CITY OF ALBUQUERQUE

August 23, 2017

**Re: Taco Cabana Cottonwood
Erosion and Sediment Control Plan
Engineer's Stamp Date 6-5-17 (B13E025)**

CITY OF ALBUQUERQUE PUBLIC WORKS DEPARTMENT	
TITLE: TACO CABANA @ COTTONWOOD EROSION PLAN	
DESIGN REVIEW COMMITTEE	CITY ENGINEER APPROVAL
LAST DESIGN UPDATE	MO./DAY/YR.
CITY PROJECT NO.	SHEET
ZONE MAP NO. B-13-Z	C-105

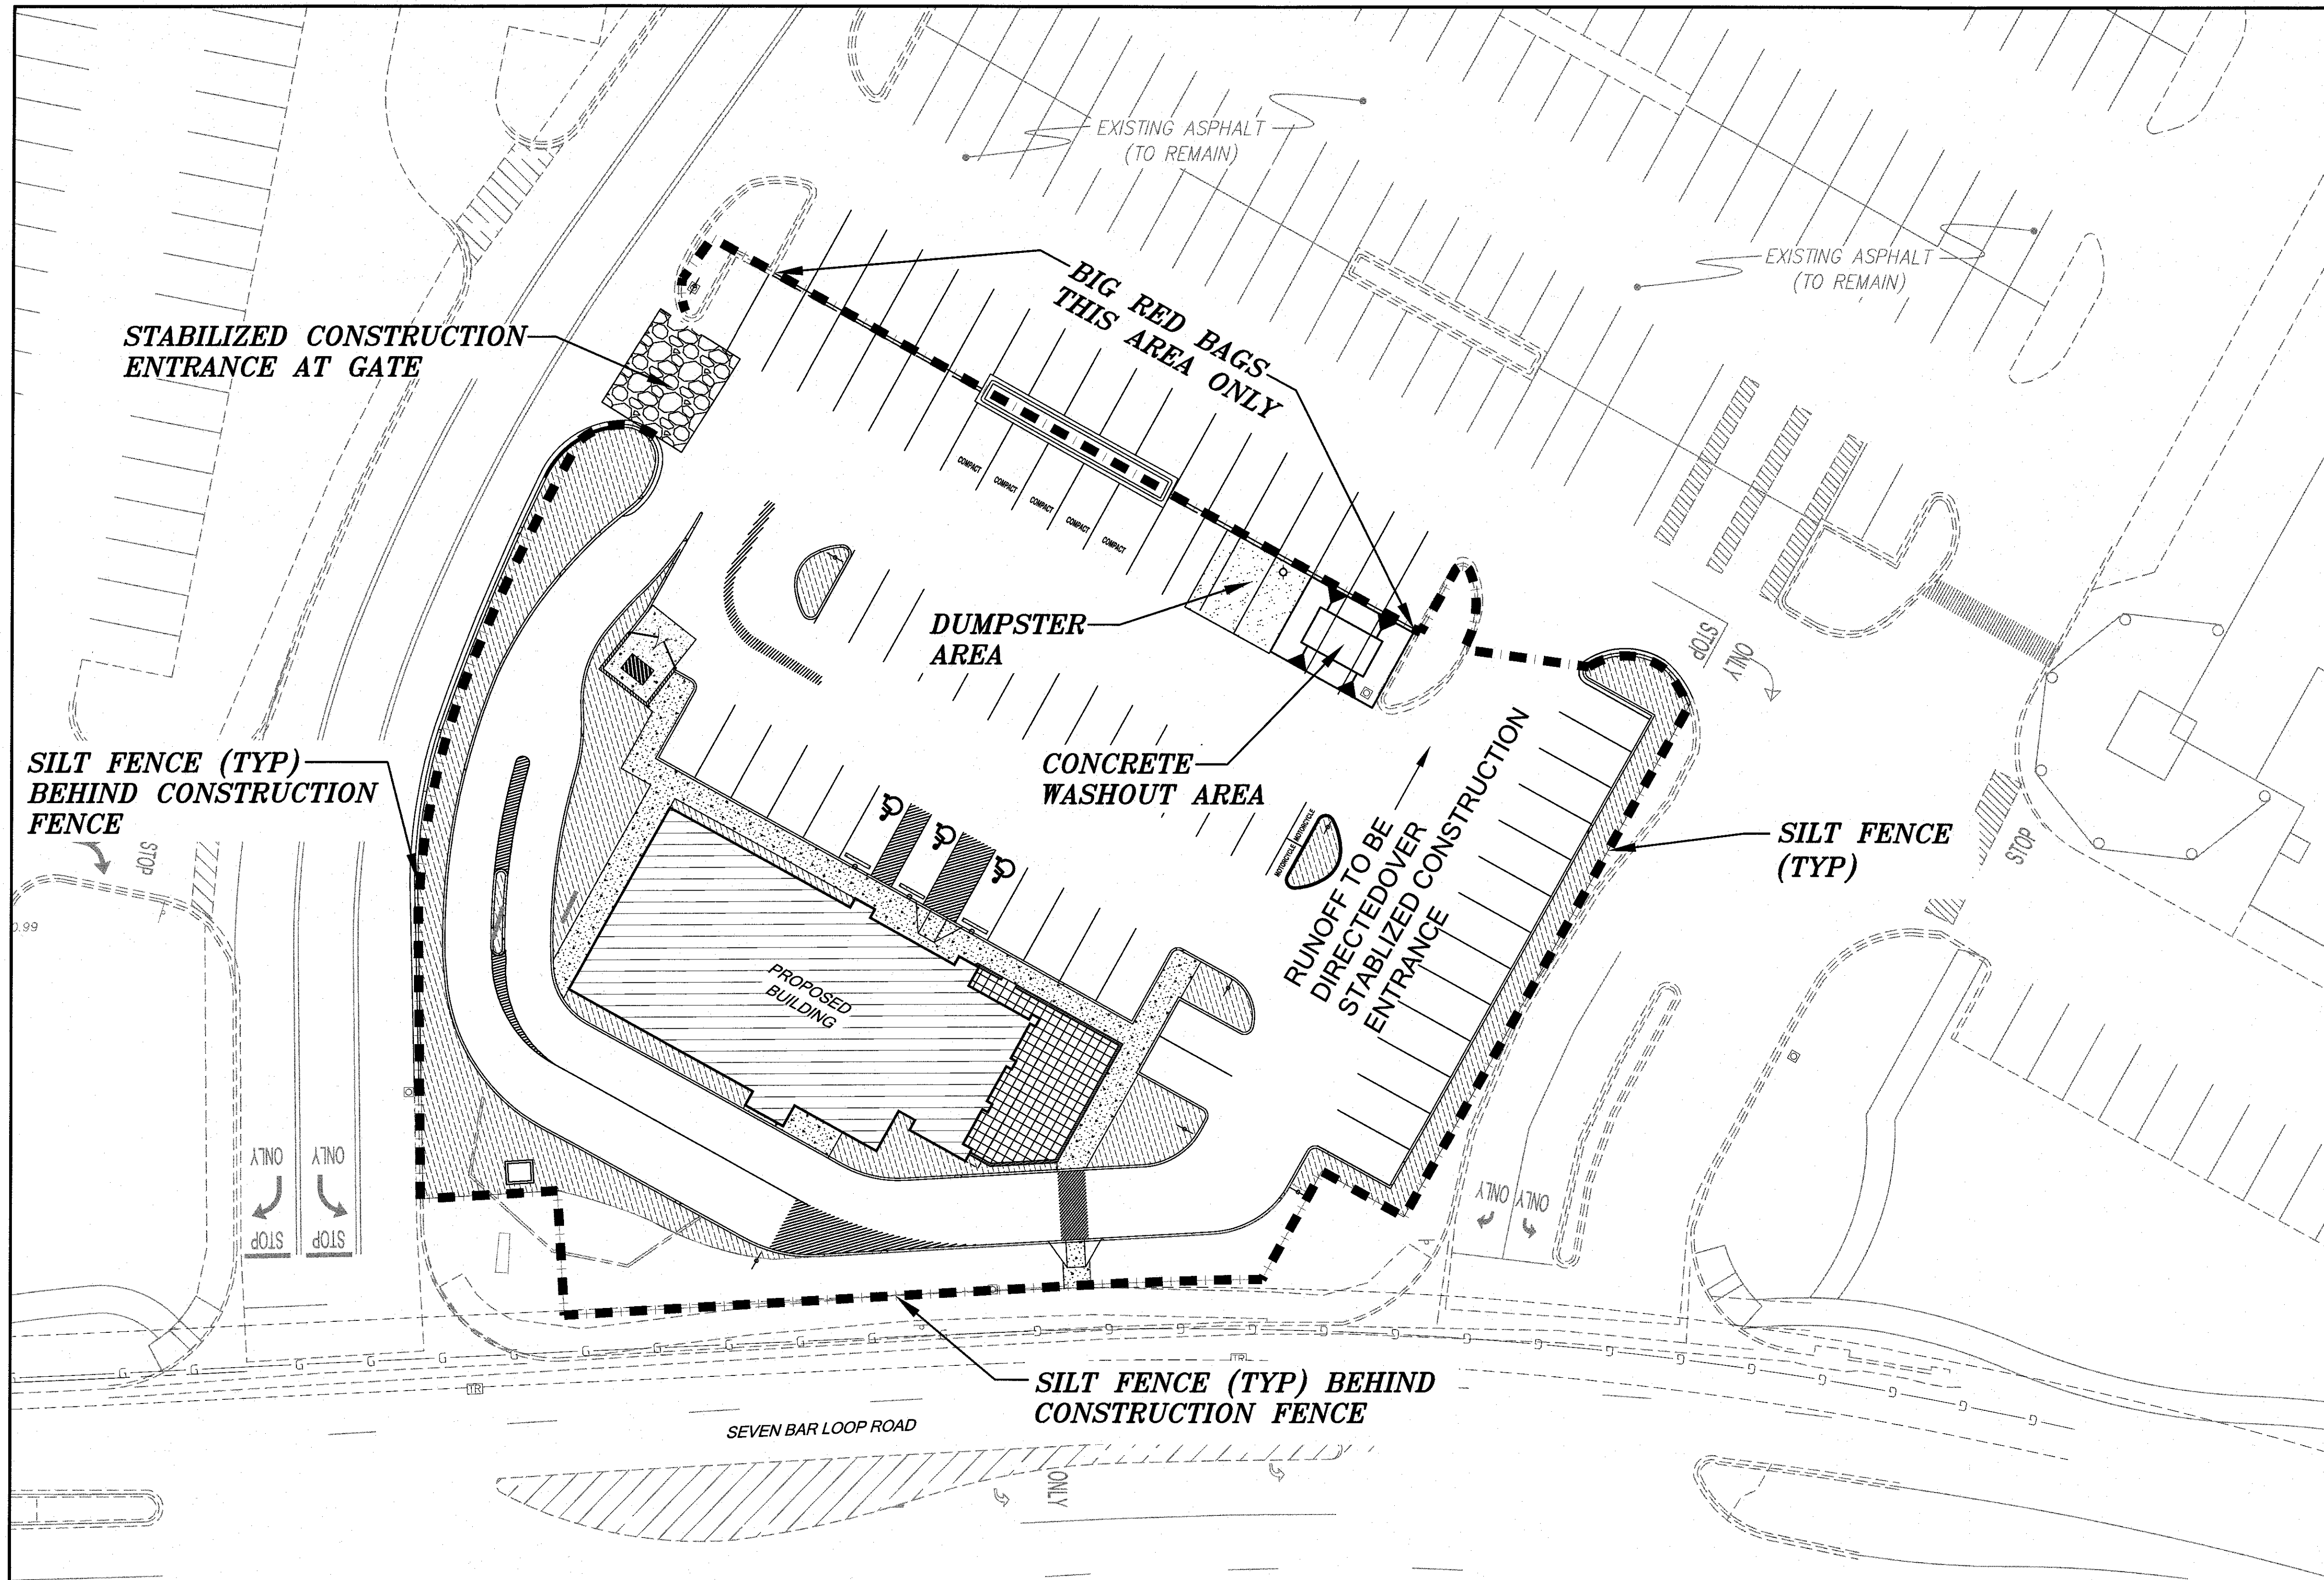
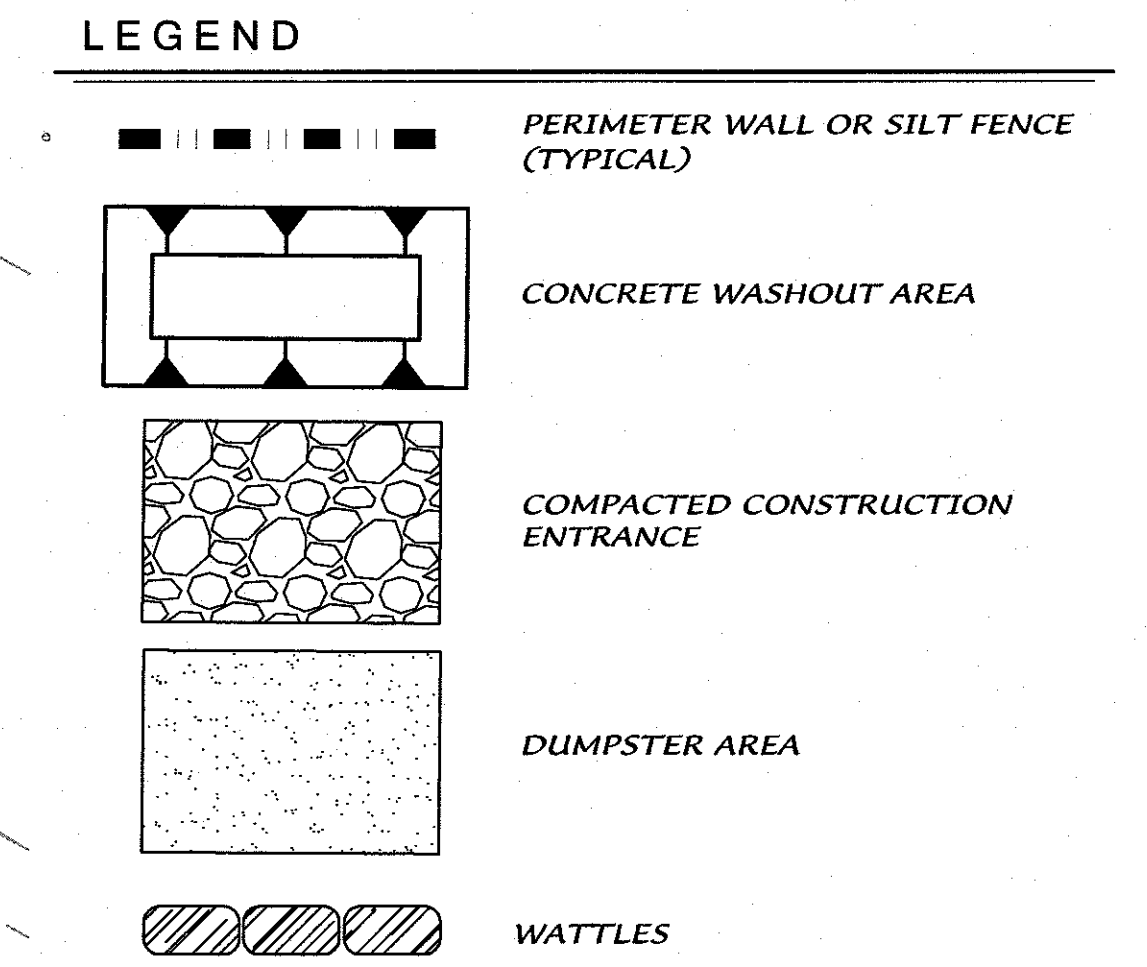
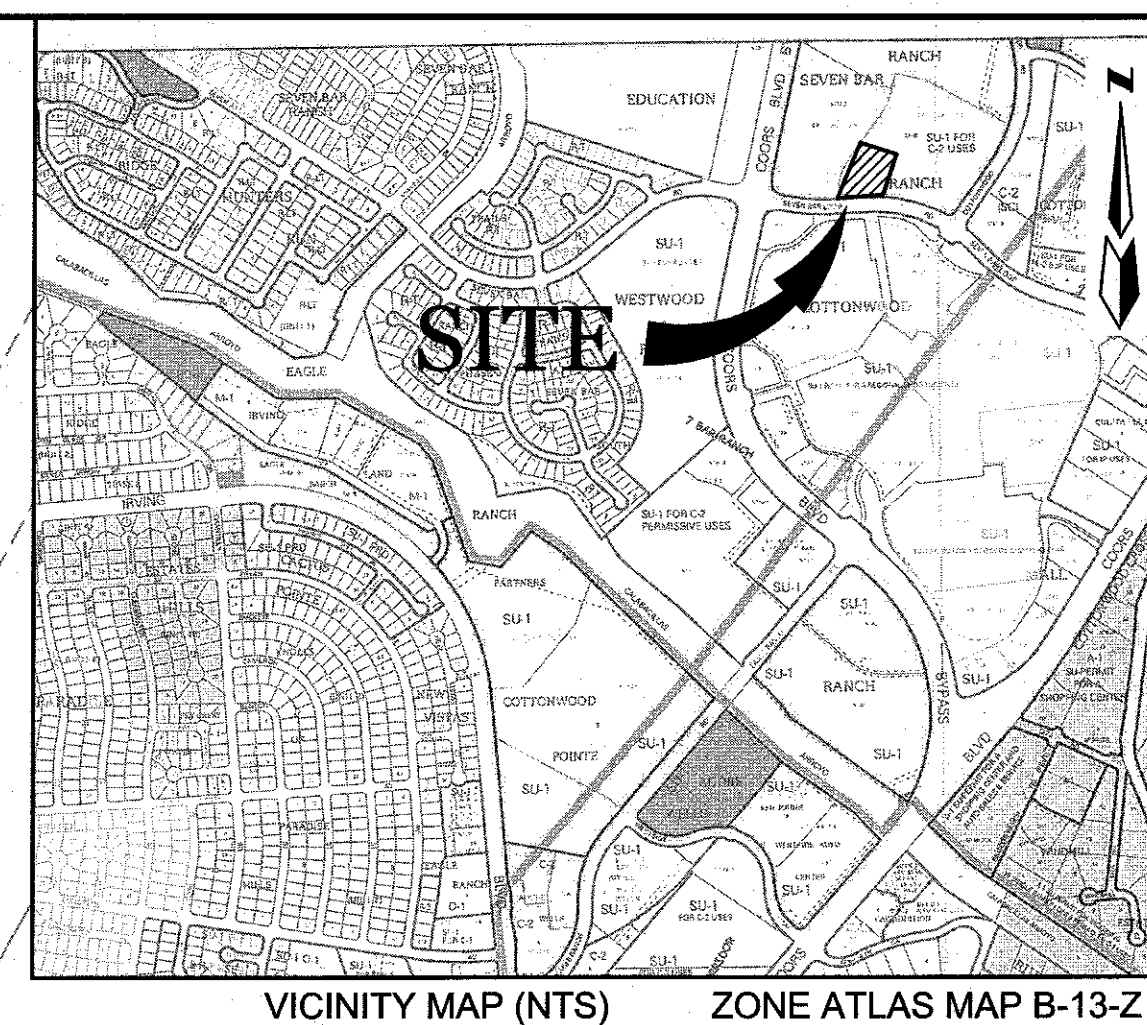
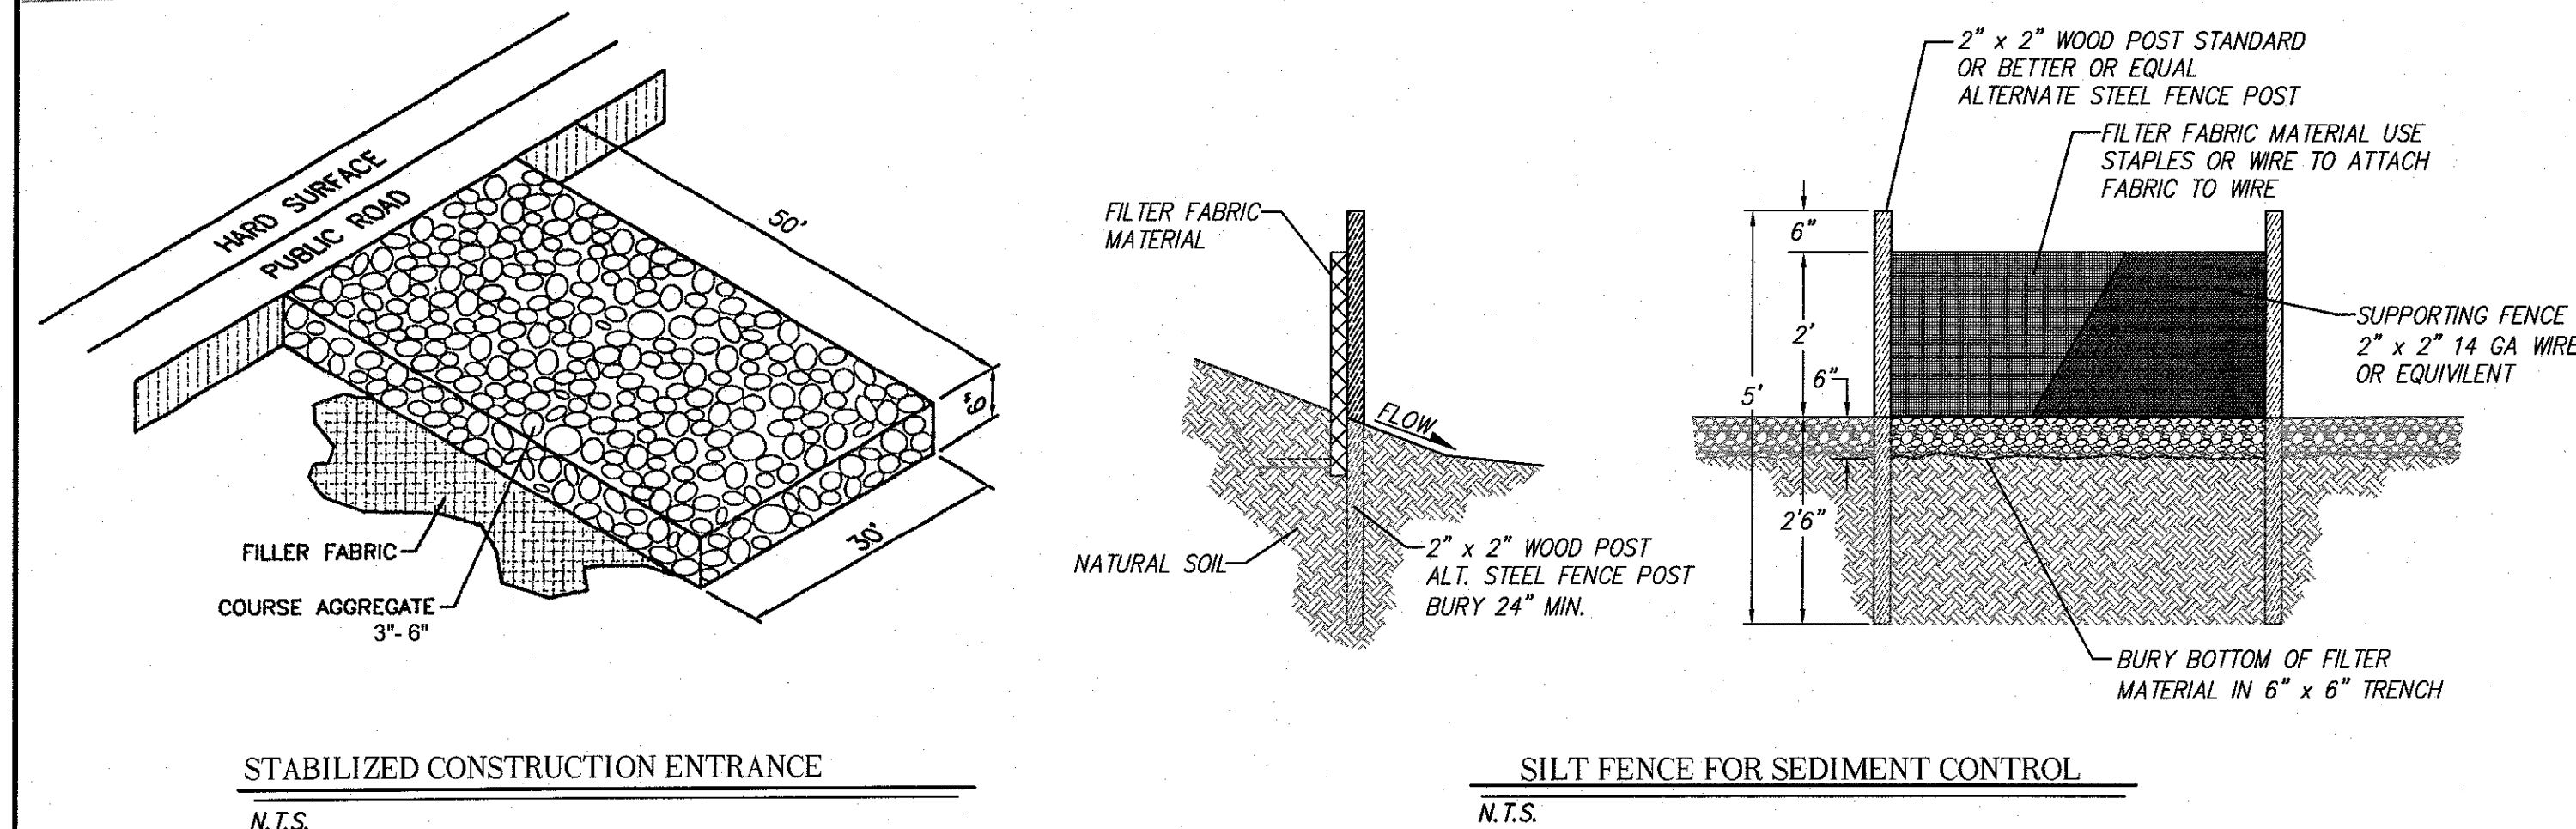
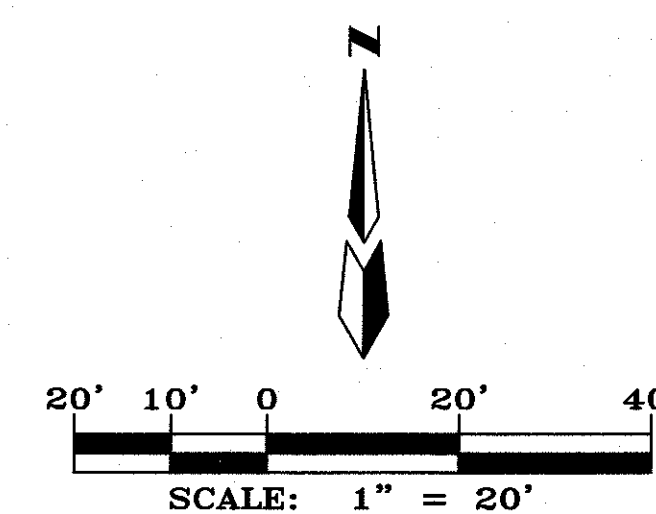
1. Remove the note that "Runoff is to be directed over stabilized construction entrance". Stabilized construction entrances are not an appropriate BMP for removing sediment from sheet/concentrated flows. In addition, the stabilized construction entrance is in a different location.

2. "Big Red Bags" appear to be a specific instance of a filter sock. It would be preferable to call-out a filter sock, then in the detail you could mention Big Red Bags or similar. Provide a detail for this type of BMP. The filter sock BMP should be proposed across the existing asphalt in the northeast corner of the project.

3. Provide a maximum pole spacing in the Silt Fence detail.
4. Provide existing and proposed topography.
5. If the western edge of the project will receive flows, a filter sock should be proposed as a sediment BMP on the asphalt surface (between parking islands), as silt fence will not create a seal on asphalt.

6. In the legend, please change "Compacted Construction Entrance" to "Stabilized Construction Entrance".
7. The plan shows the legend item "silt fence or perimeter wall" in the area where filter socks (Big Red Bags) are proposed. The legend also includes wattles which are not called out as a BMP. To clean this up, replace the "wattle" legend item with "filter sock" and use this legend feature where the filter socks will be used.
